**Application AL/137/24/RES – Land to the rear of Meadow Way, Westergate.**

In reference to the above reserved matters application, Aldingbourne Parish Council objects to this application based on the following:-

## PROPOSALS

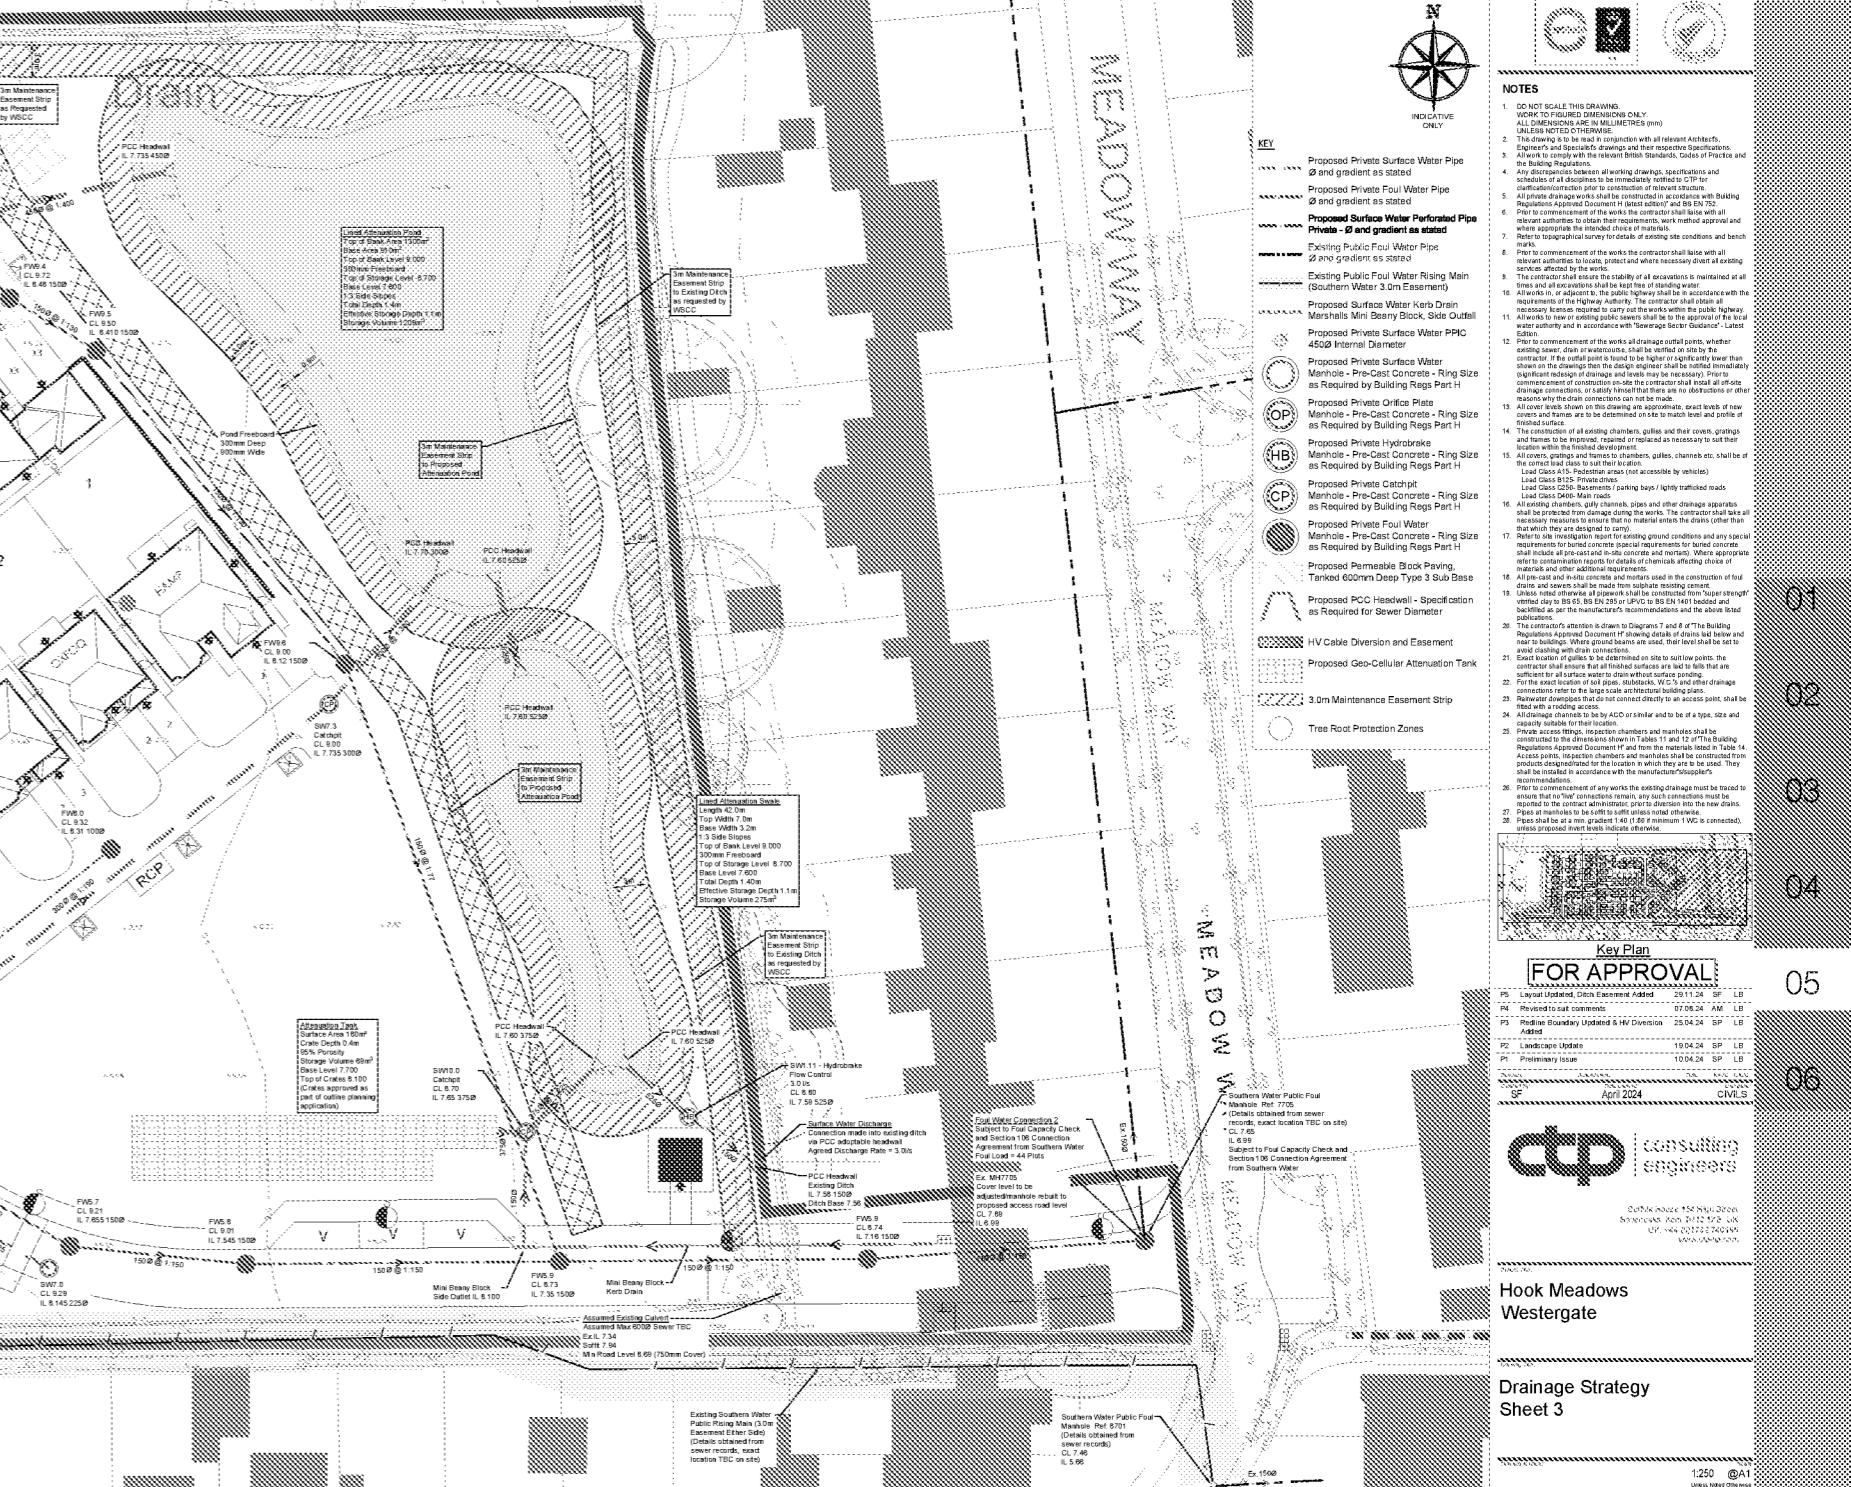
The council also observes with regret that the Planning Officer's comments in Report AL/50/24/RES in relation to surface water drainage have not been adequately addressed (or at all) in re-submission AL/137/24/RES and the Applicant's current proposals do not comply with ANP EH5.

Para 6.37 of the Henry Adams submission describes the intended SuDS including final discharge from the attenuation ponds "*into the existing ditch on the southeastern corner of the site*". This corner is where the development is accessed from Meadow Way. The existing ditch itself flows into an existing area that is at "High Risk" of surface water flooding for existing properties and the A29 road (see Surface Water Flooding Risk Map on GOV.UK using 24, Meadow Way as search locator).

There is a material risk that the outflow of surface water from the development will flood the access onto Meadow Way and the properties and part of the A29 that are already at High Risk of surface water flooding. The applicant's current surface water drainage strategy does not comply with ANDP

**The council considers on the available information and evidence provided, the absence of the updated report and calculations etc required by WSCC is a material omission, and that the proposals in AL/137/24/RES constitute a material risk of increasing the likelihood of surface water flooding in Westergate. The current proposals as understood do not properly address the Planning Officer's concerns and do not comply with ANDS EH5**

4.1.1 The general principle of the surface water drainage system comprises a total of 3 attenuation ponds with two located centrally within the site and a larger one in the north-east corner of the site. The two central attenuation ponds would be on-line ponds with the outlet discharging to downstream pipes in the drainage network. All the surface water will drain to the larger pond in the

*4.1.2 The surface water drainage system is only designed and intended to drain some of the roads and roof areas. It is not intended to drain all the roads and none of the car parking areas. Some of the roads and all of the car parking areas are designed as having permeable pavements but the submitted drainage plans are incomplete and are inadequate to show what areas are drained by the positive drainage system and which areas are intended as permeable pavements.*

*4.1.3 The Drainage Strategy report states (paragraph 2.21) that the permeable pavements will need to be lined. It is therefore not known how the applicant intends the permeable pavement areas to be drained as the 'lining' will prevent them from operating as permeable pavements.*

*4.1.4 The surface water drainage system as currently designed is therefore inadequate to drain the whole site*
